# CITY OF ALBUQUERQUE

RE: **Juan Tabo Hills Estates**  
**Revised Grading Plan**  
**Engineer's Stamp Date: 8/9/18**  
**Hydrology File- M21D018; DRB# 1005278**

Based on the submittal received on 8/17/18, the revised grading plan cannot be approved until the following are corrected:

SECTION C-C SCALE: 1"=20' H 1"=10' V

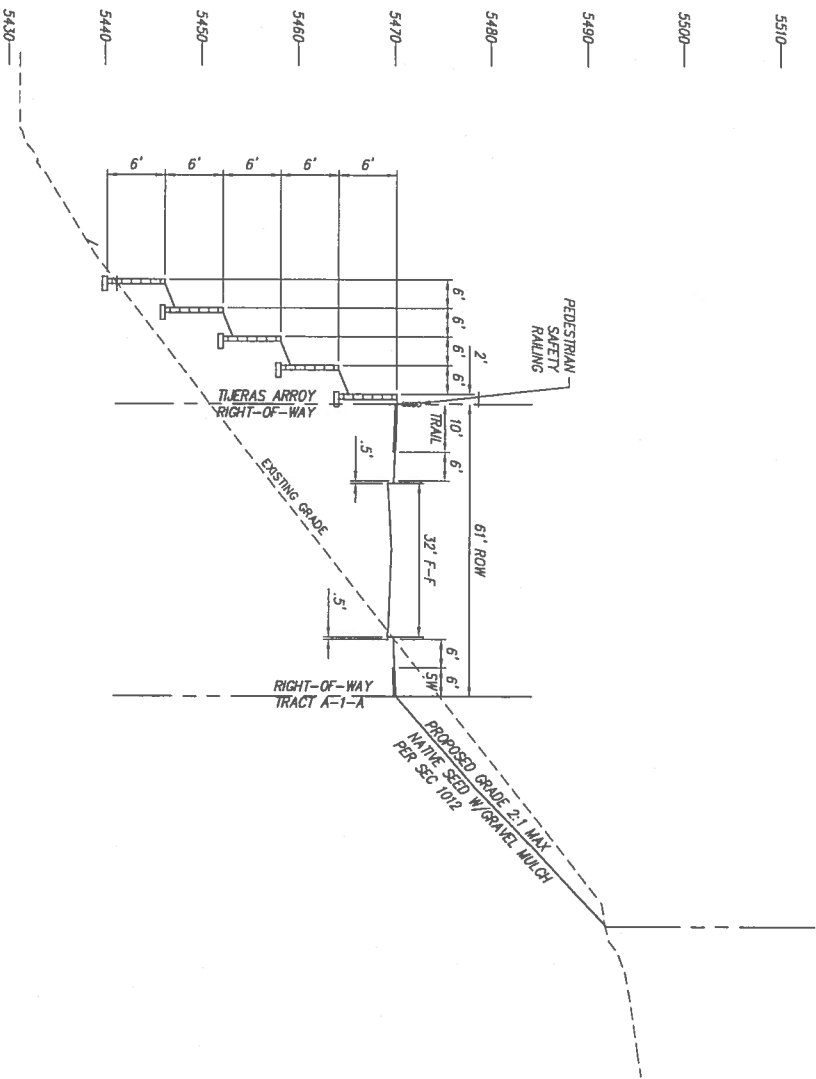
2. Provide an armored drainage conveyance for the interspaces between the terraced retaining walls and down into the storm water pond; ensure the AMAFCA access road is protected from this runoff. The section C-C inset, showing the V-swale with riprap needs to be provided for each terrace of the retaining walls.
